**Re: EXHIBITION OF STATE SIGNIFICANT DEVELOPMENT
APPLICATION SSD-10389**

PROPOSAL:	LIVERPOOL HOSPITAL REDEVELOPMENT
ADDRESS:	CORNER OF ELIZABETH AND GOULBURN STREETS, LIVERPOOL HOSPITAL

DRAWING TITLE  
**CAMPBELL ST SHARED WAY**

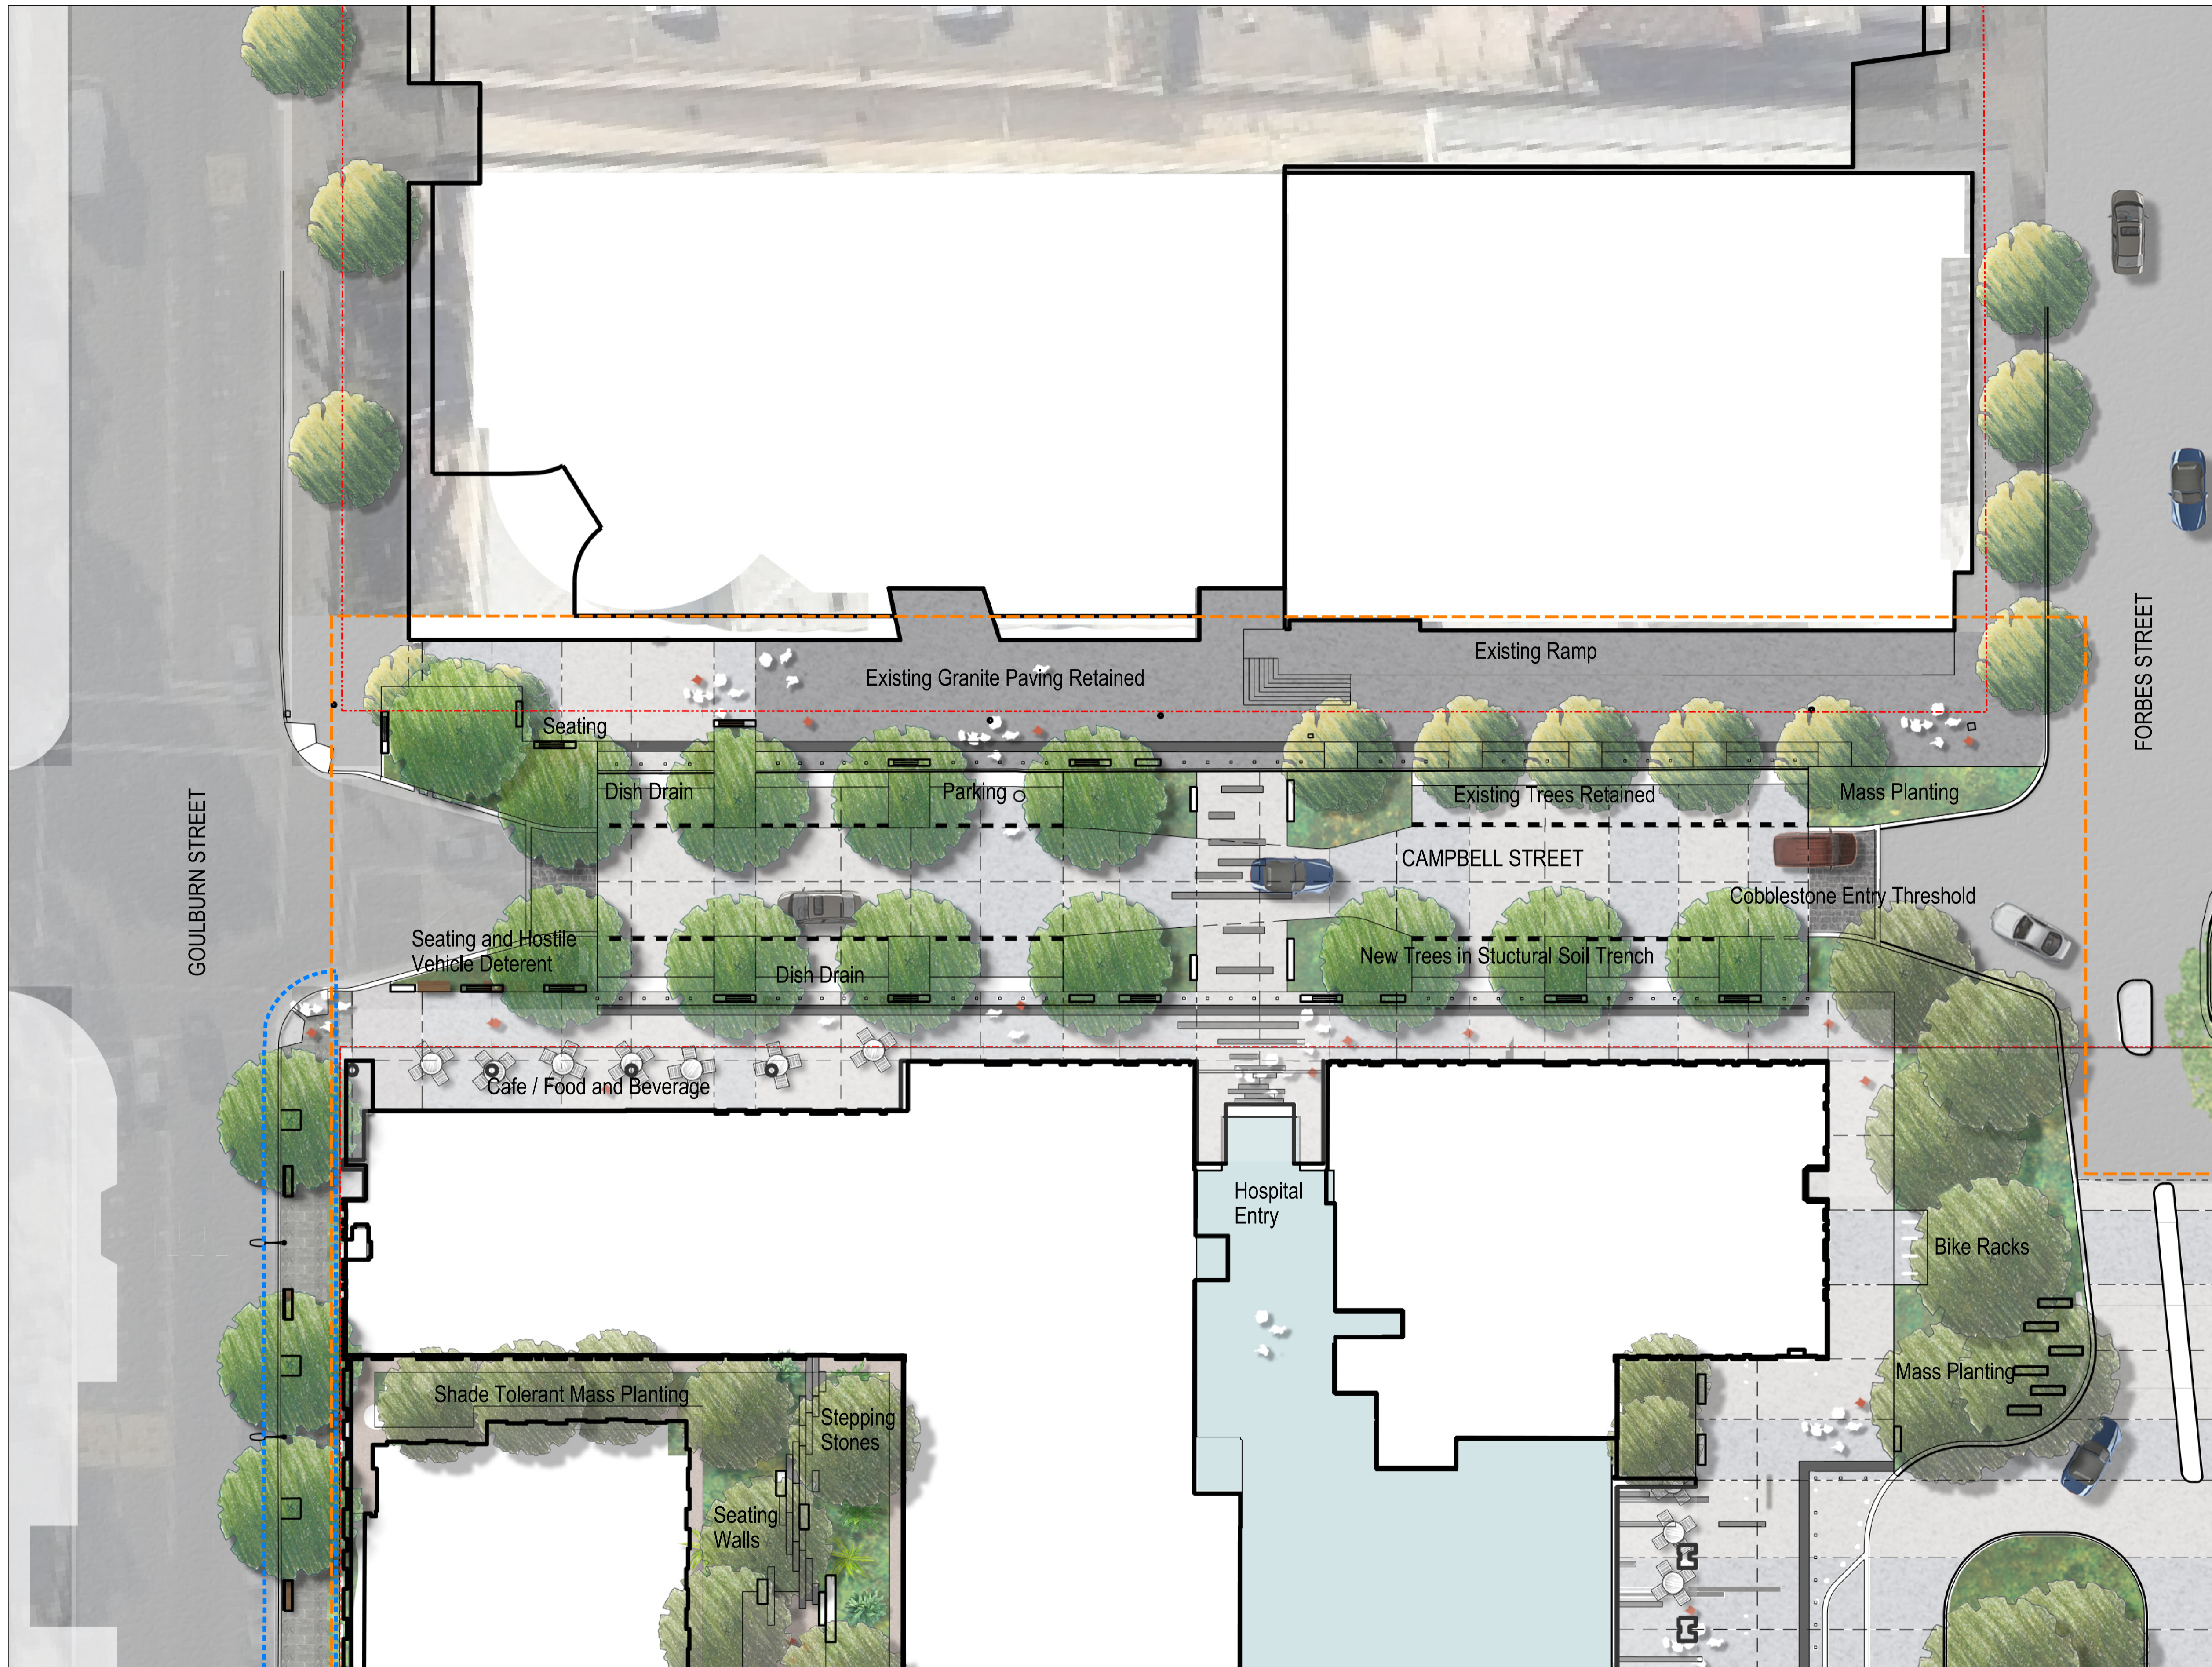
5. Concern is raised in relation to the proposed 10km/h shared zone along Campbell Street between Goulburn Street and Forbes Street.

Campbell Street is currently carrying approximately 700 and 450 vehicles in the AM and PM peak hours respectively. To meet TfNSW 10km/h shared zone criteria, traffic flow along Campbell Street will be required to reduce to less than 100 vehicles per hour and less than 1,000 vehicles per day.

Based on traffic volumes at Campbell Street and Forbes Street intersection, 93% of traffic is from Goulburn Street South and Campbell Street East. The proposed directional signage plan on the north to the development site might not be effective to reduce traffic from Campbell Street to less than 100 vehicles per hour.

The section of Campbell Street to be changed is currently a bus route and section of bus routes 851, 853, 854 and 857, and a school bus route for the adjoining high schools.

The proposed one-lane two-way slow point within the shared zone will have a significant impact on the bus operation and traffic movement. Consultation is required with TfNSW, bus operators, the schools and the endorsement of the Liverpool Pedestrian Active Transport and Traffic Committee.

As such, the proposed 10km/h shared zone along Campbell Street between Goulburn Street and Forbes Street is to be deferred as part of this development, for the applicant to carry out the above consultation and referral to the Liverpool Pedestrian, Active Transport and Traffic Committee.
